ADC PARKS & GREENSPACE ARBORICULTURE

PLANNING APPLICATION: A/10/15/PL

ADDRESS: Land at West Drive Ham Manor Estate Angmering BN16 4JF

BRIEF DESCRIPTION: 2 No. detached houses with garages

Tree Survey Schedule

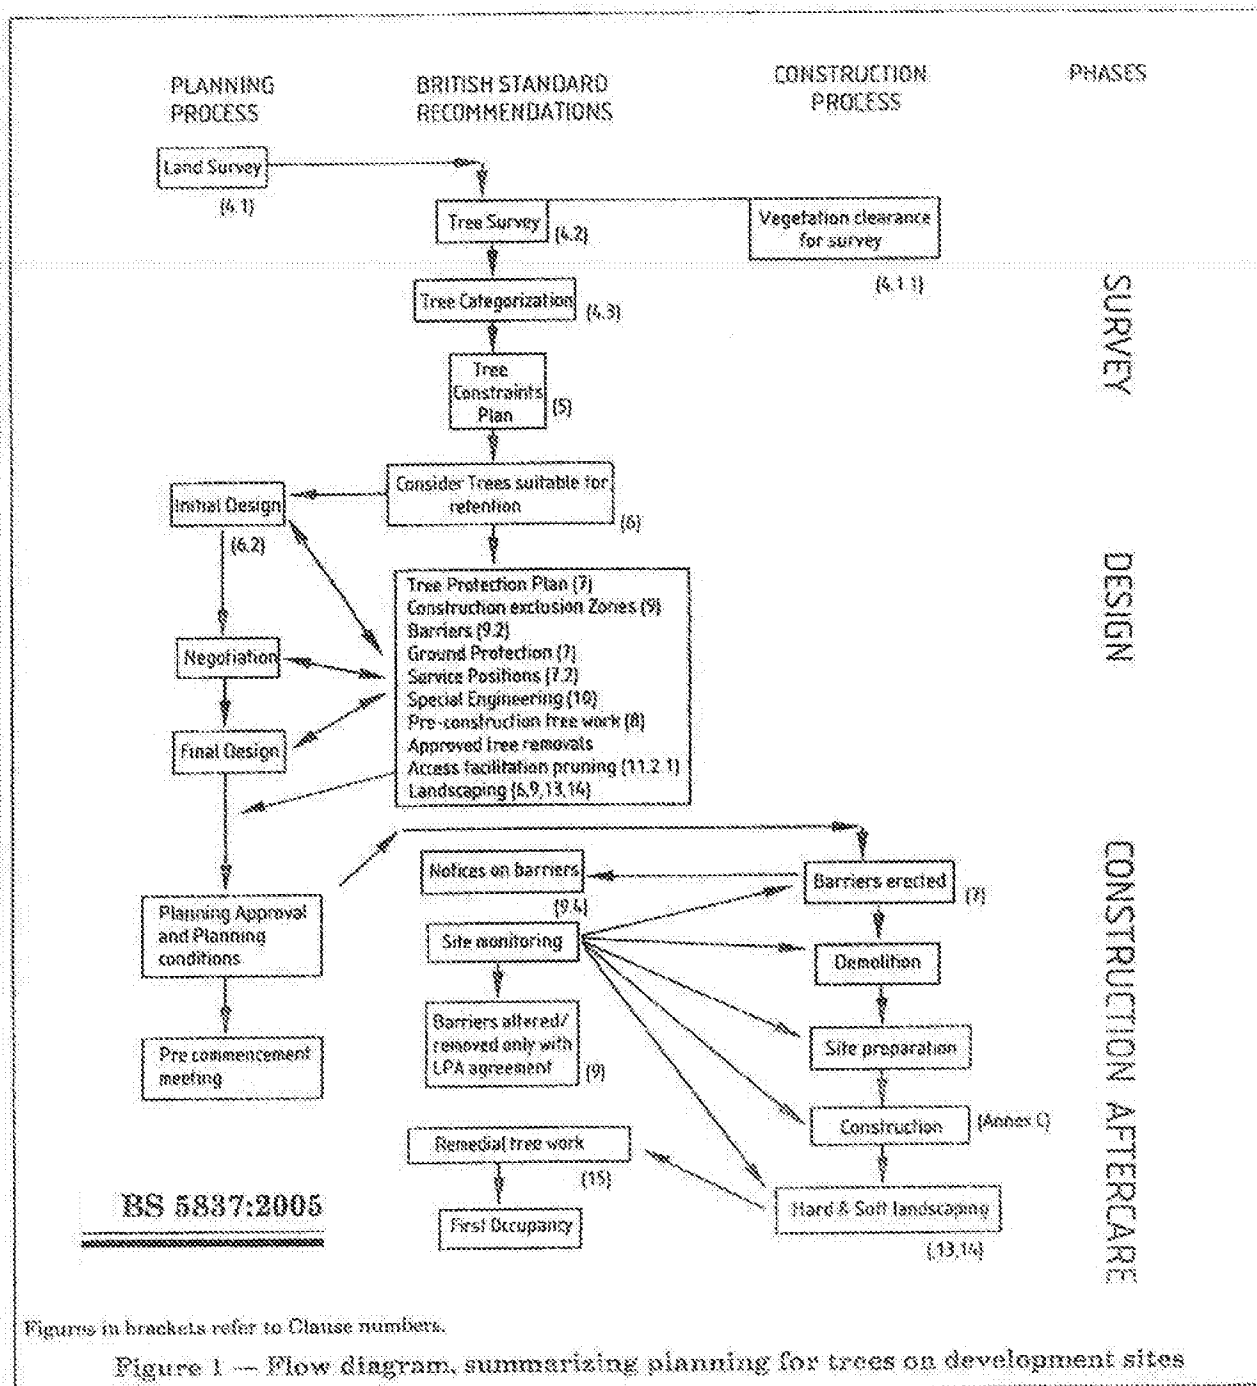
- The outlined area of land is located in Ham Manor are. This 'private' estate has an unusually high stocking density of early/semi/over mature trees of varying species. this area of land does have established trees that mainly stand in liner lines along the western and southern boundaries.
- The submitted the application has outlined the desire to build 2 x detached houses with detached garages. From the block site plan submitted, it is evident the Root Protection Area (RPA) of the established trees will have no overlap with the proposed development.
- The submitted tree survey schedule has identified the following pruning works to undertaken to the following trees;

T1 – remove basal suckers – basal growth is regarded as a symptom of stress experienced by **T1**. The removal of such growth is seen as good industry practise. This practise is clearly not designed to accommodate the development and/or the construction process.

G2 – this group of sycamore/s trees has already been removed. This has been completed in accordance with permission from the planning inspectorate.

- The applicant has cited the intention of retaining all the onsite trees.
- The method of protection of the established trees on site does appear to meet the standards set by the BS 5837:2010.

- As the submitted tree constraints, tree survey report, and retention span have meet the standards set by the BS 5837:2010, **I have no objection to the proposed development process.**
